Our Ref: FP/252/21/DOC

Approval of details reserved by condition imposed under ref FP/52/21/PL relating to Condition Nos 3 - bin storage, 7 - electric vehicle charging and 8 - covered & secure cycle parking.

107 Felpham Way Felpham PO22 8QB

Doc No
019-DLS-00-00-DR-A-1011

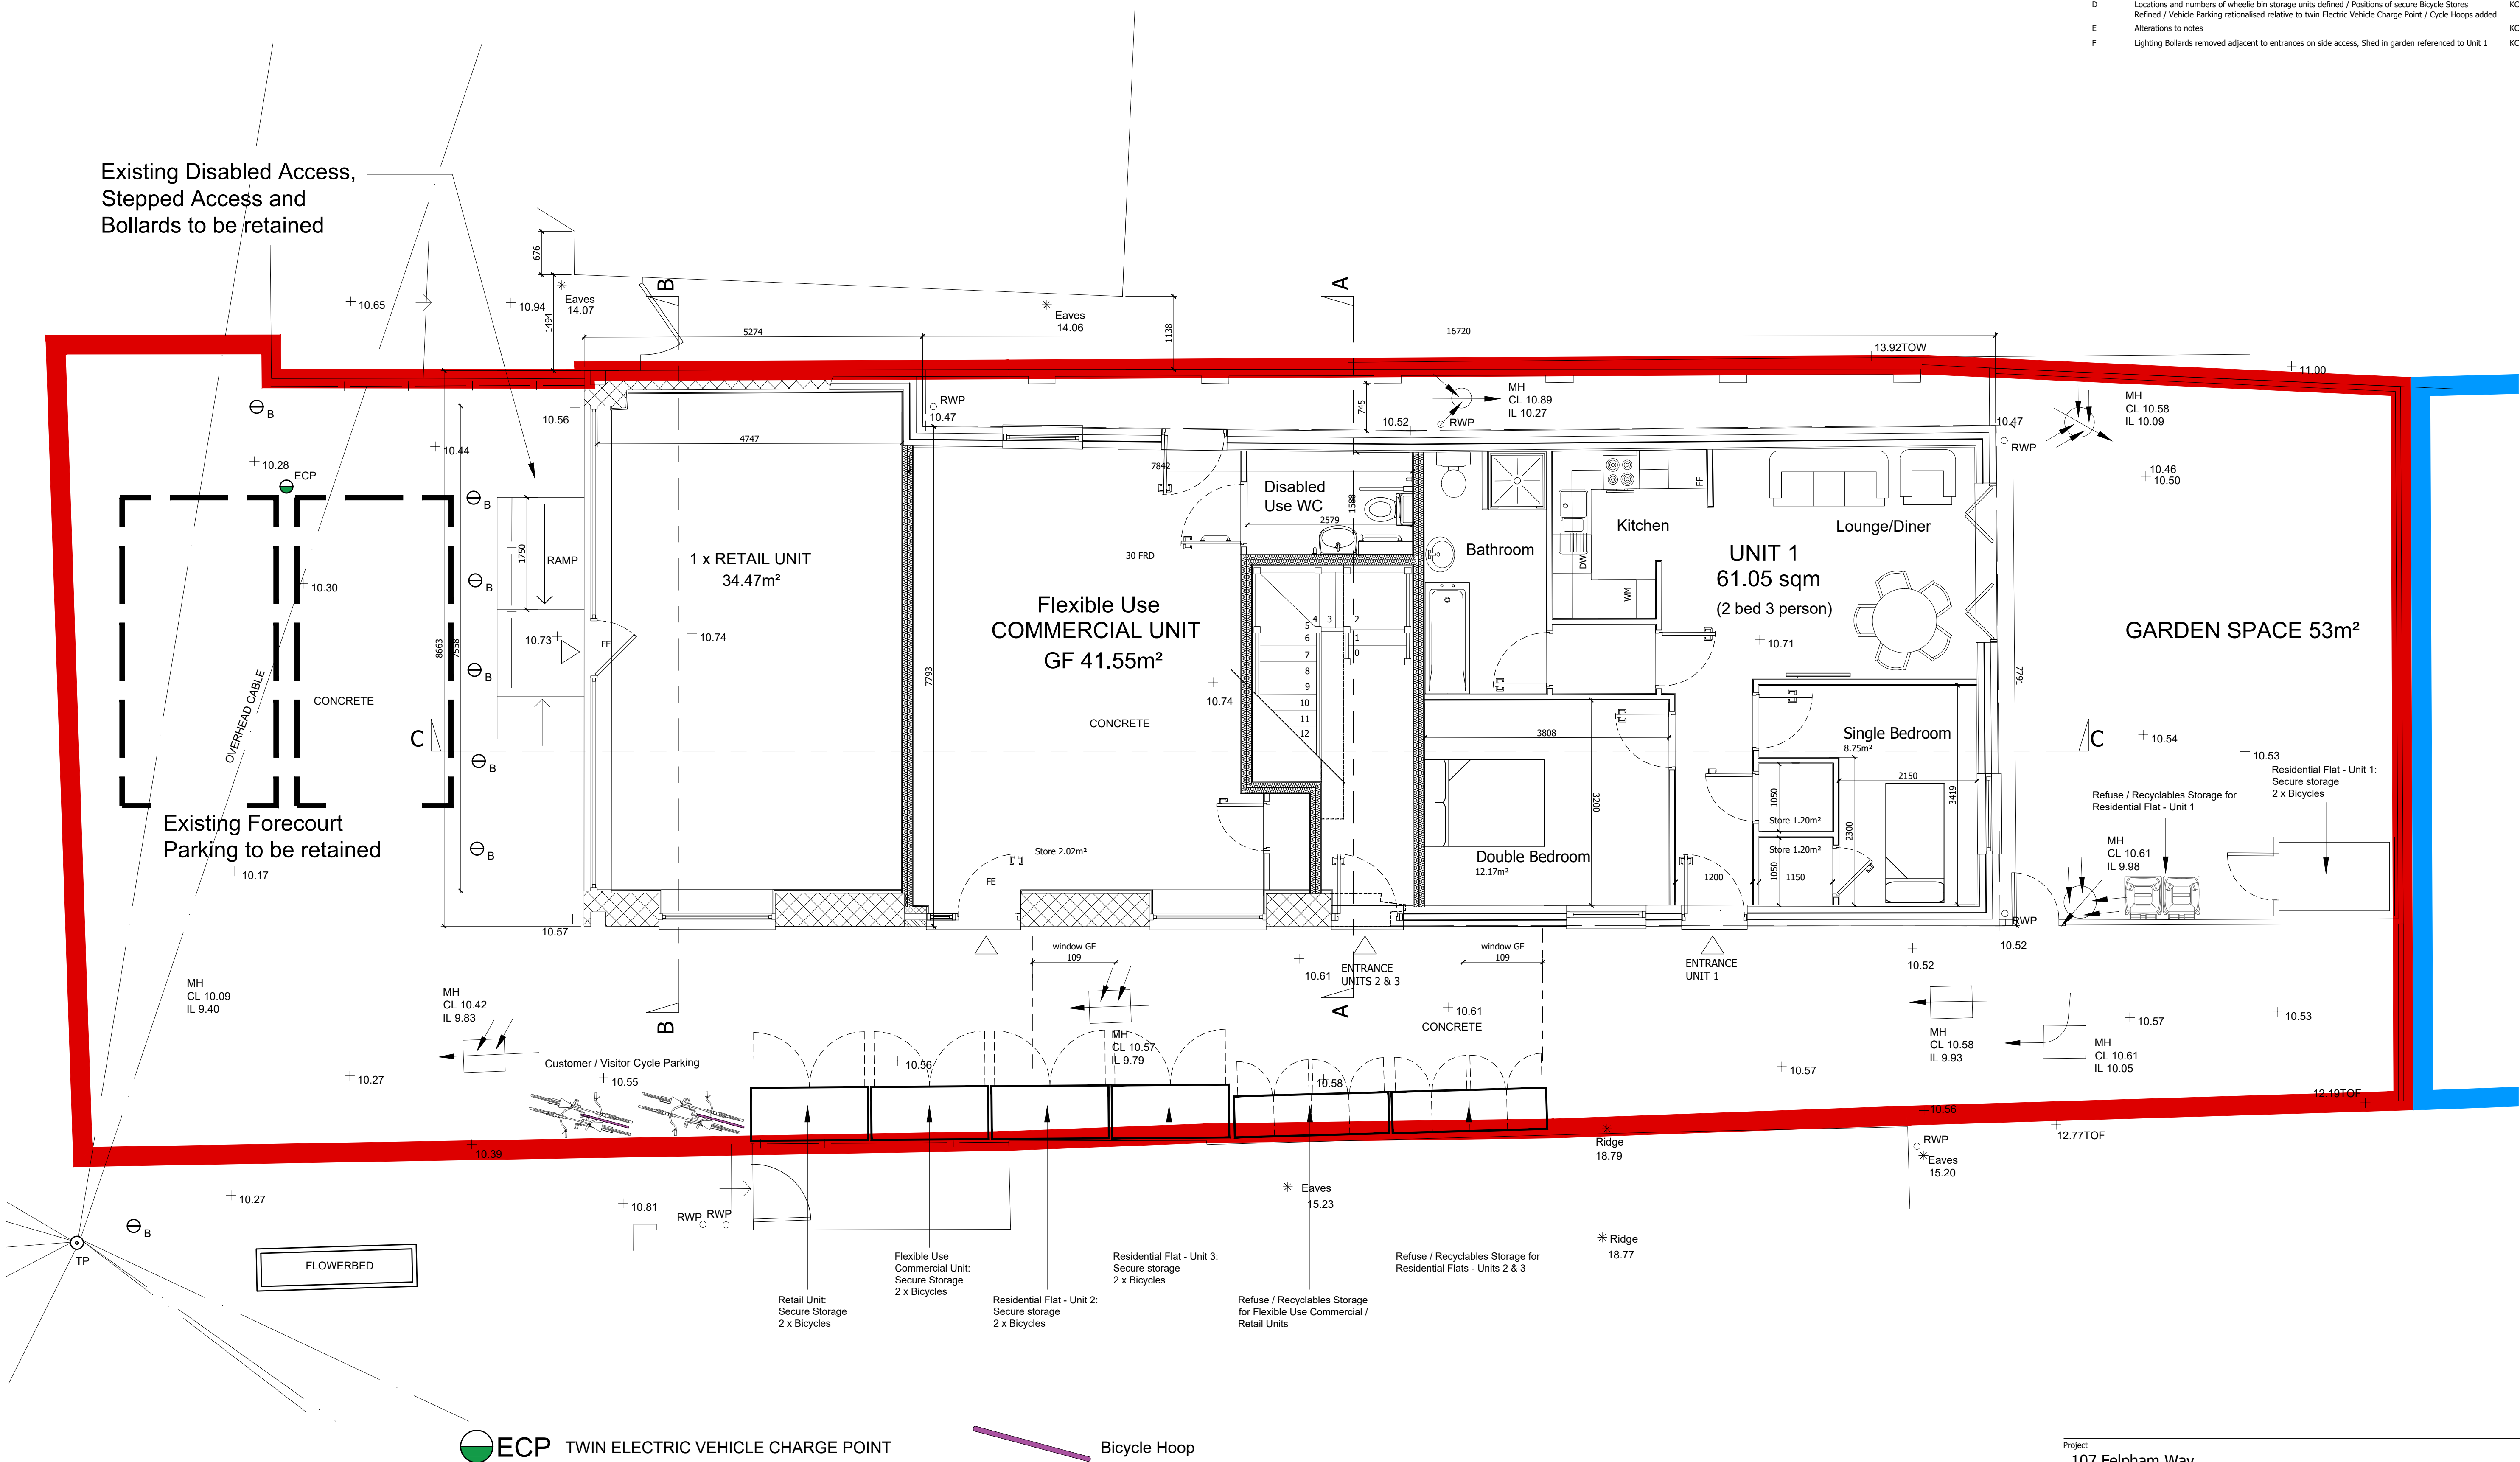
The submitted details in respect of refuse and recycling bins have been provided and space has been laid out for the storage as shown on Drawing No. 019-DLS-00-00-DR-A-1011 F, Site Plan, dated 22/11/21 are considered to be appropriate and satisfy the requirements of the condition.

The condition is therefore fully discharged insofar as the submission of details relates and on the understanding that refuse and recycling bin storage areas shall not be used for any purpose other than the storage of refuse and recycling bins.
